My name is [REDACTED] **Morningthorpe and Fritton Parish Council.**

East Pye Solar - EN0110014

Morningthorpe and Fritton Parish Council – Follow-up from ISH1

- Sites
- Proposed BESS
- National Grid Substation Site and Point of Connection
- National Grid Substation Option 2 Site and Point of Connection
- Cable Route Corridor
- 1A Site/Sub Site Number
- CRC1 Cable Route Corridor Number

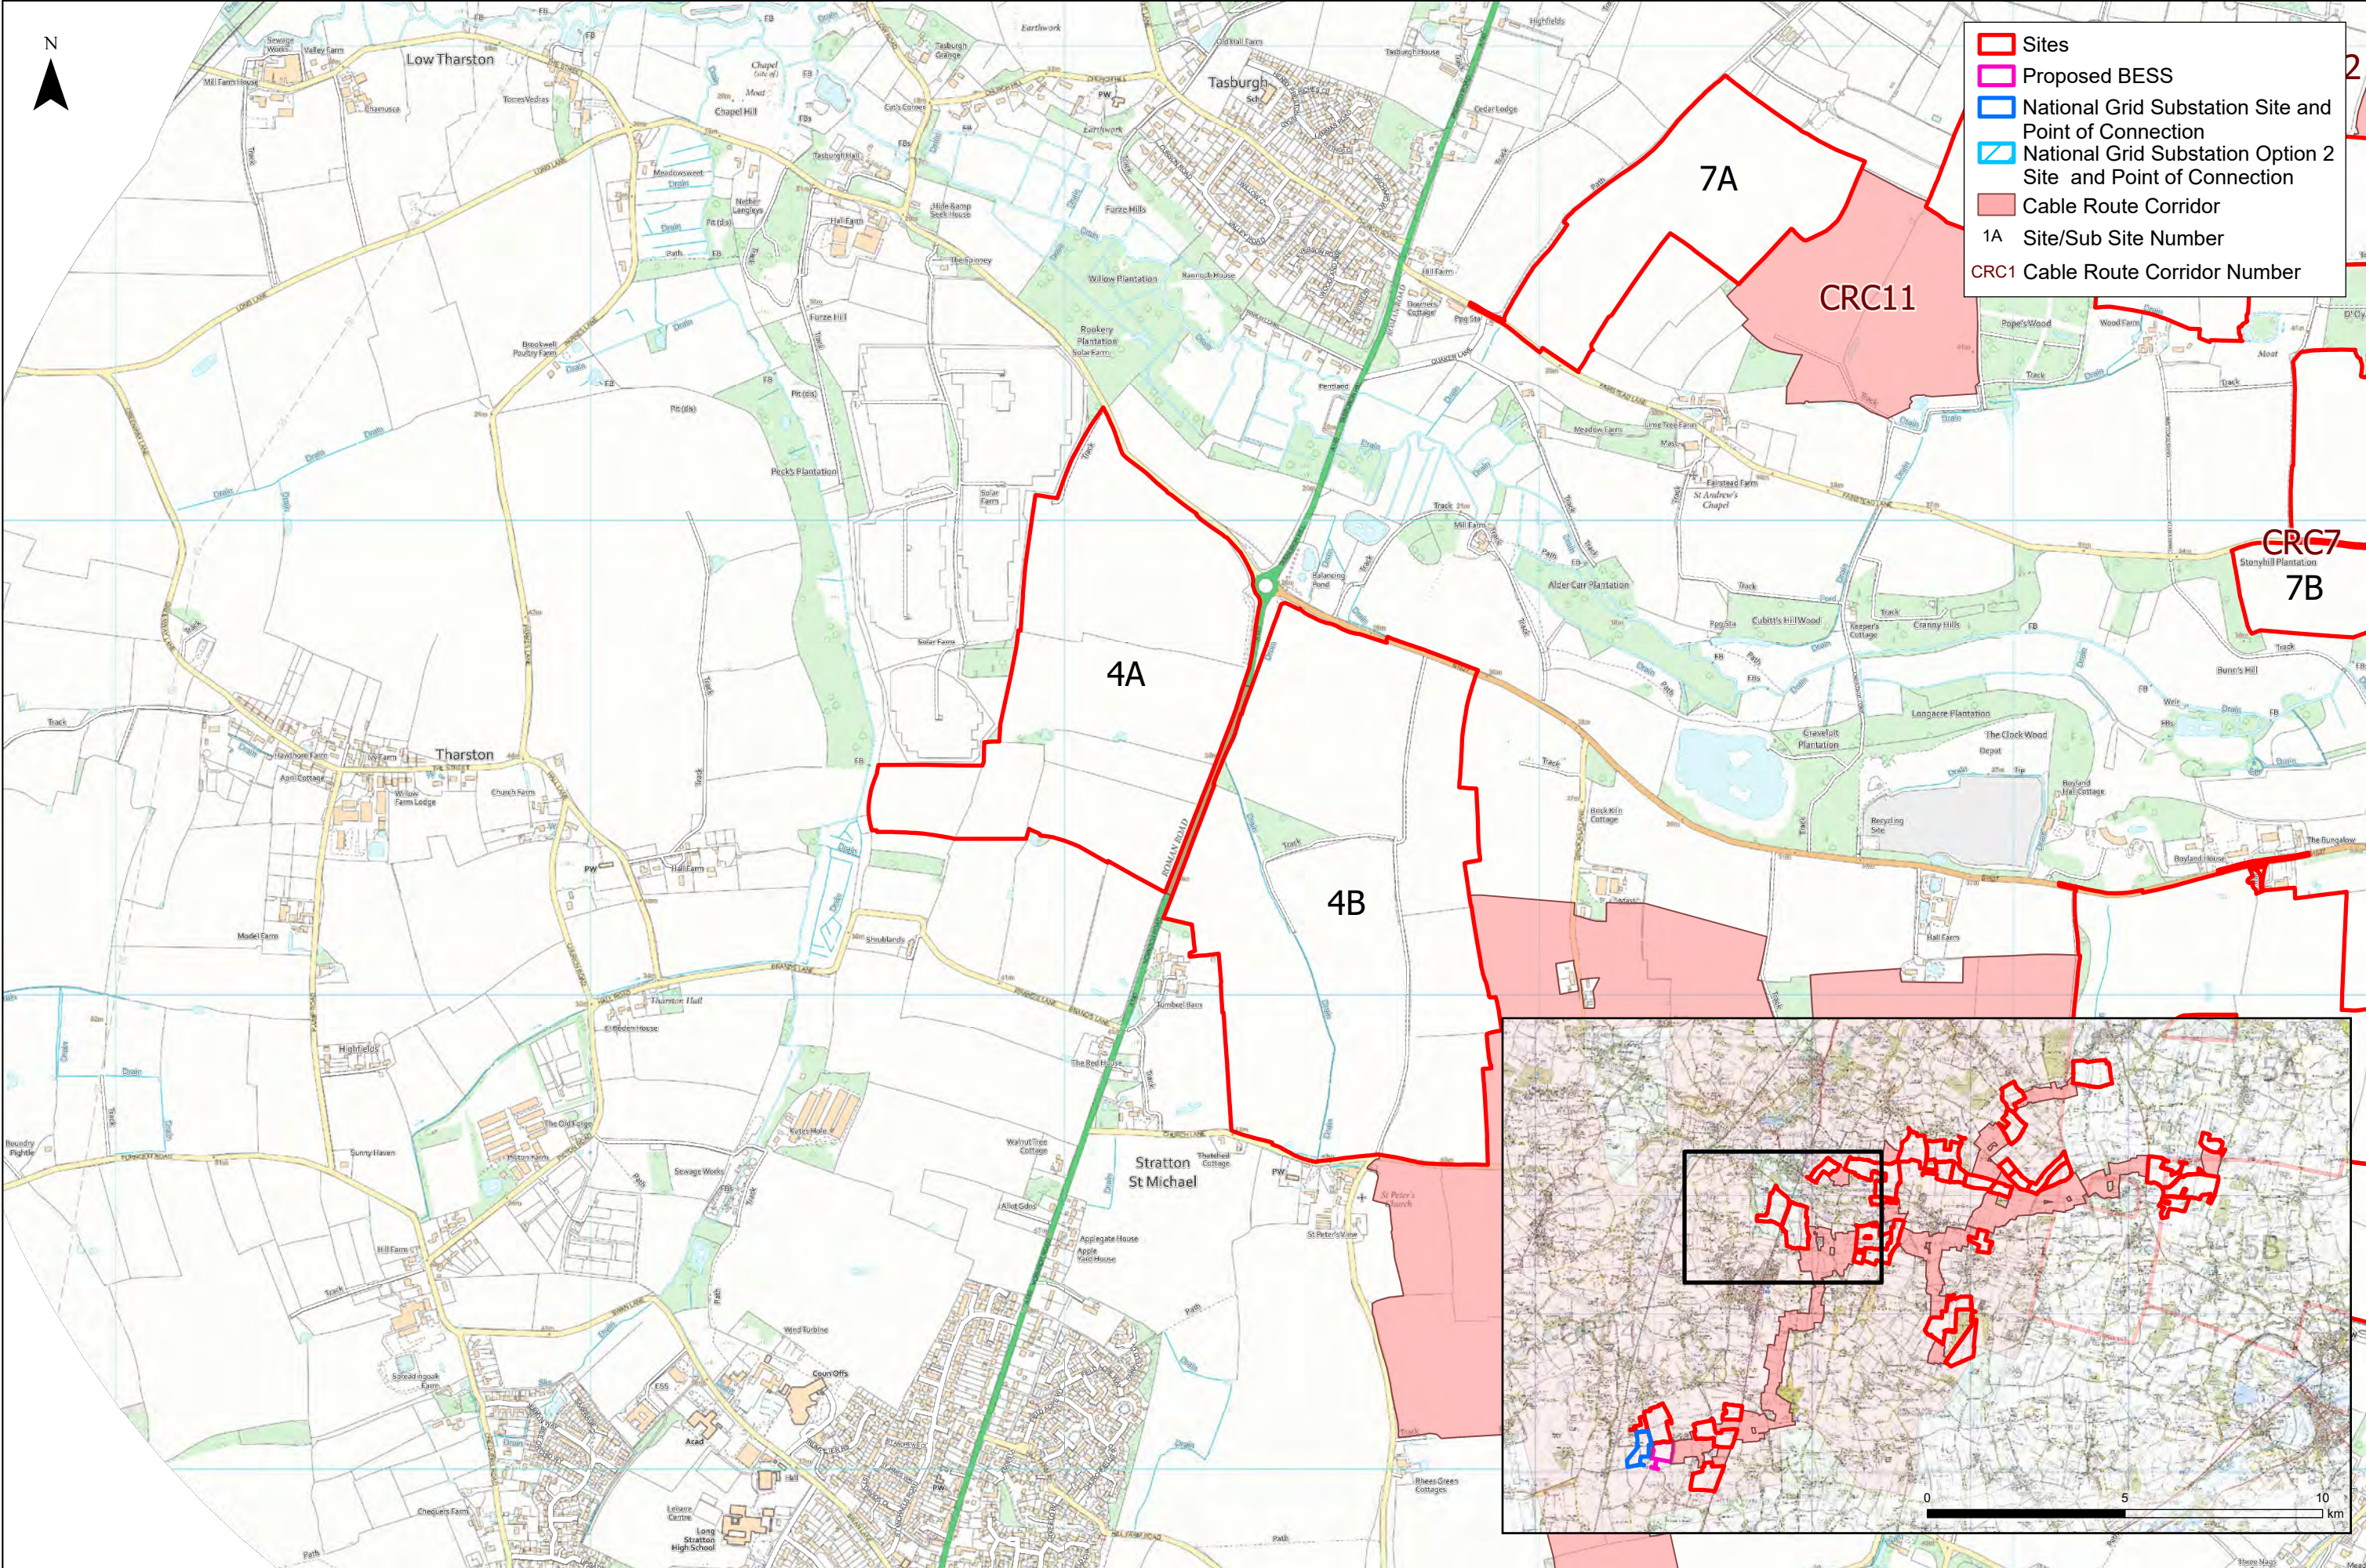
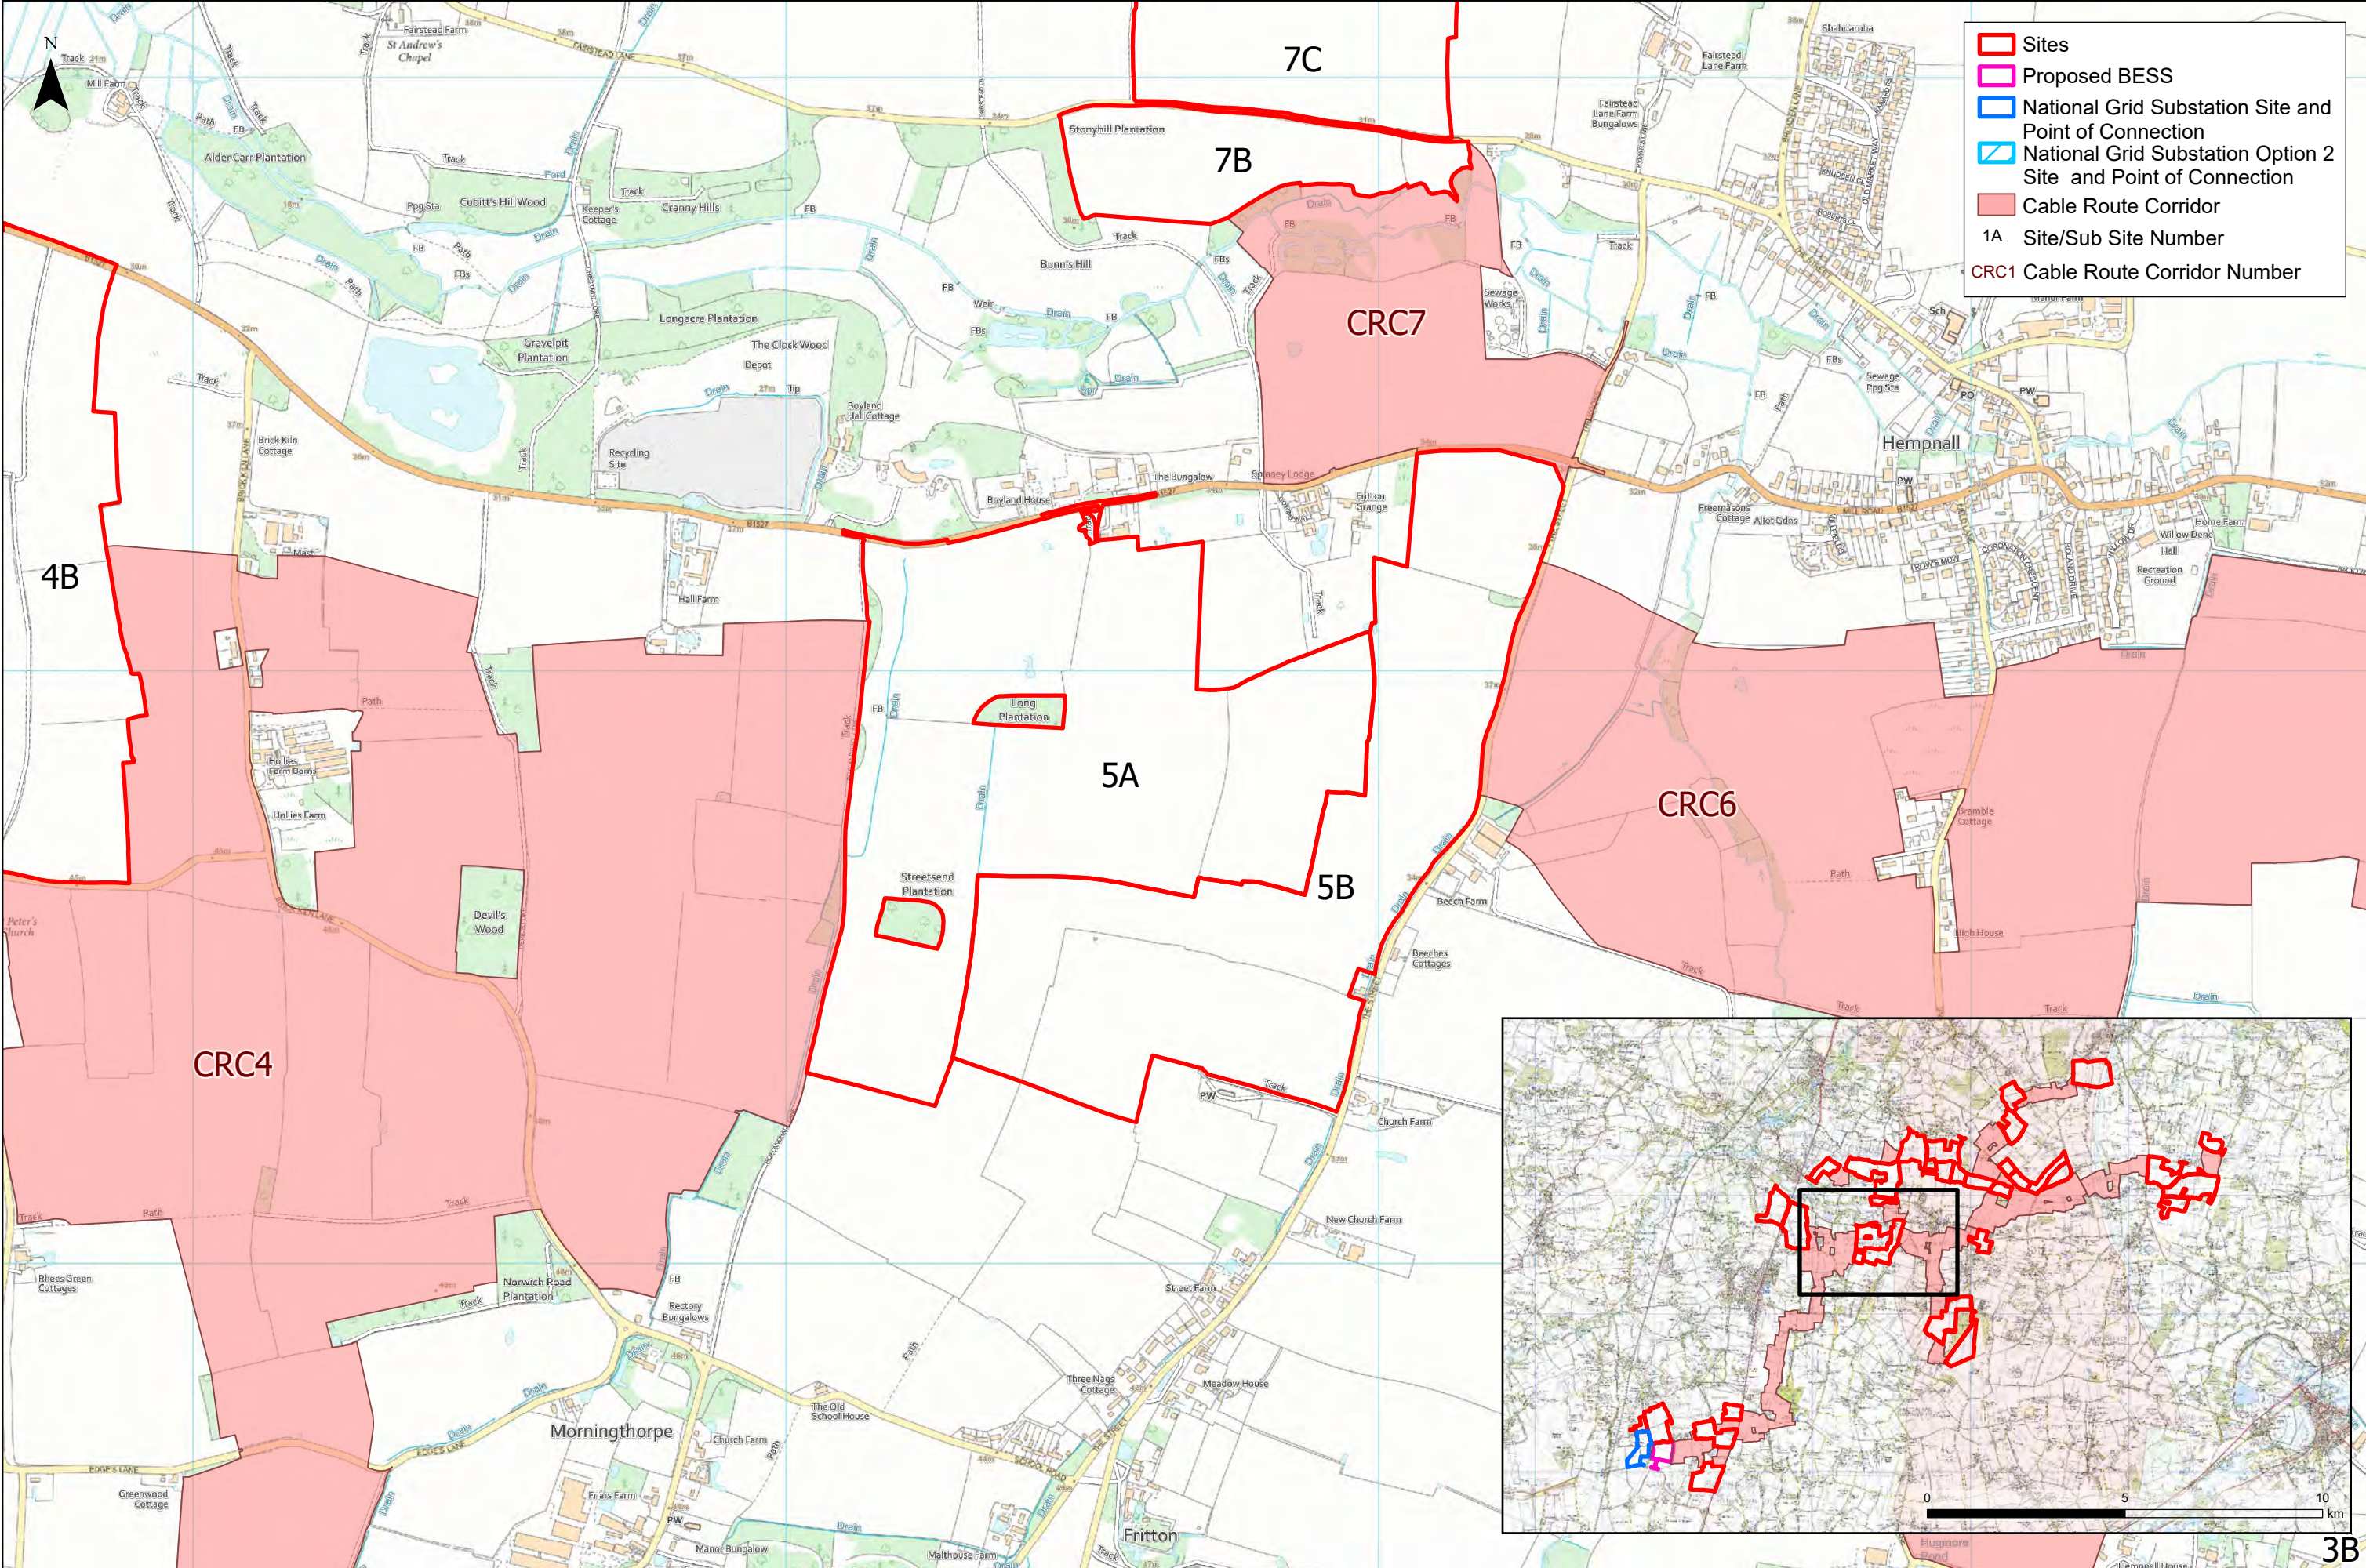
Site 5 would introduce a **13m high 400kV substation, 4.5m high tracking panels, transformers, construction compound, fencing, lighting and CCTV** into countryside in and around Fritton and Morningthorpe.

Site 5 contains many of the very constraints the Applicant says should be avoided: sensitive landscape, nationally important heritage, high-quality agricultural land, ecology and nearby homes. Yet the Applicant has not demonstrated that Site 5 is the least harmful location.

Yet our review identifies 7 residential properties omitted from the construction-noise assessment, 4 for vibration assessment distance, and 6 for the highway noise distance. Approximately 70 residential properties lie within 500 m of Site 5 for operational noise and have been omitted.

Site 5 also occupies much of the northern foreground when approaching Fritton, where the transition from open countryside into the historic village remains remarkably intact.
